Internal Ref: EXTERNAL/2024/0020

Inner West Council Response: SSD-76927247-Mod-1 – The Timberyards by RTL Co.

Property: Lots bound by Victoria Road, Sydenham Road, Farr Street and Mitchell Street, Marrickville NSW 2204

Building E (New Annex)

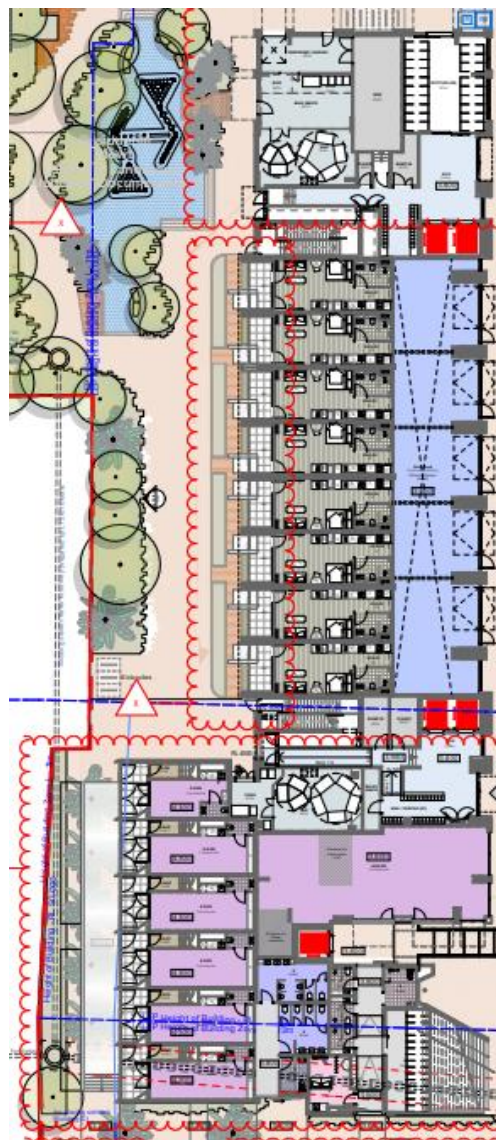
In addition to the above, the proposed amendments to Building E would result in the building having no communal living areas for residents that satisfy the minimum dimension requirements. The public area on the lower ground level proposed for market-related activity should not be relied upon as communal living area for the purposes of the co-living component. As Building E contains 76 co-living rooms, a minimum of 170sqm of communal living area, with minimum dimensions of 3 metres, should be provided within the building. Council considers that the removal of the ground level communal living areas would result in a poor amenity outcome for future occupants of Building E, as residents would be required to travel to adjoining buildings to access other communal facilities.

Approved SSDA - DA-110-007_ Ground Level - Victoria Road

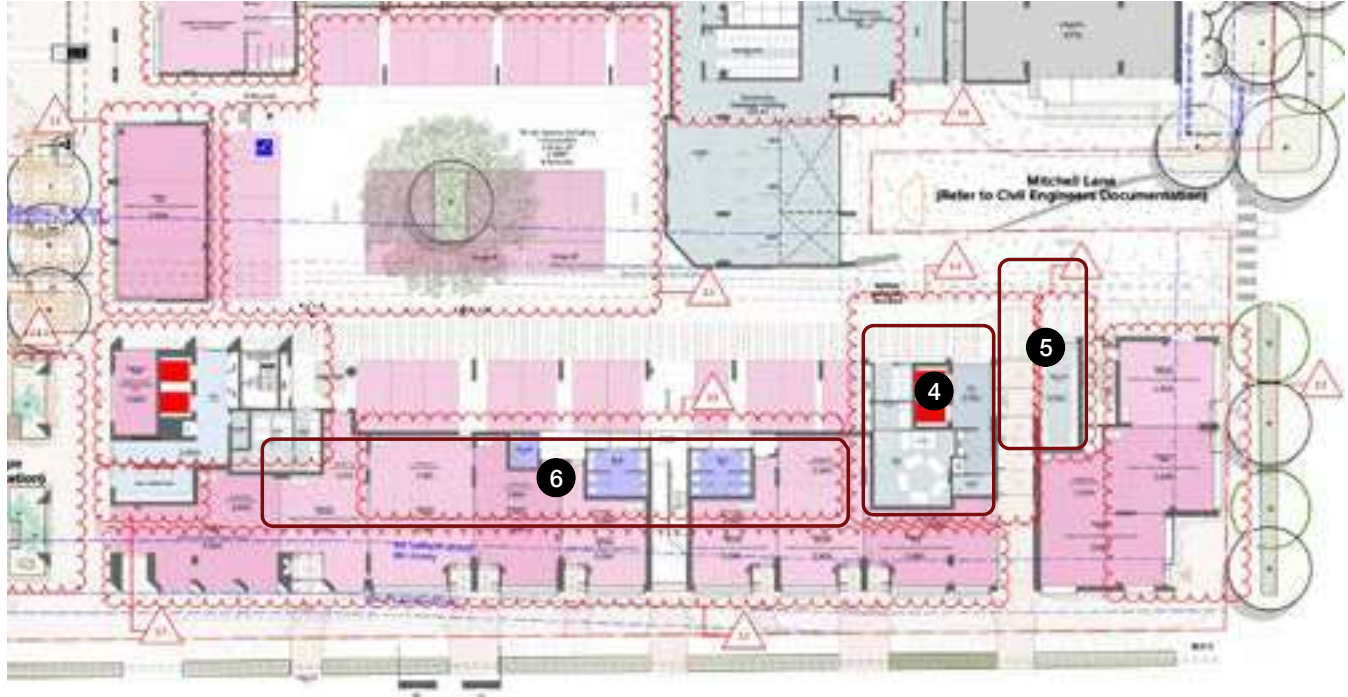
- The proposed parking between Buildings A and C/D supports the revised retail strategy and has merit. However, this outcome is at the cost of sacrificing a substantial area of conveniently located communal space at ground level.
- Page 43 of the Design Report prepared under section 4.55 states that the parking area *“has been reconsidered as a landscaped courtyard space centred around a large tree and open-to-sky oculus, creating a softer and more integrated public domain outcome.”* To ensure this objective is achieved, consideration should be given to increasing the size of the planting area around the tree and providing additional landscape treatment within, or around the perimeter of, the parking area. It is acknowledged that this may require the deletion of one or more car spaces to facilitate this.
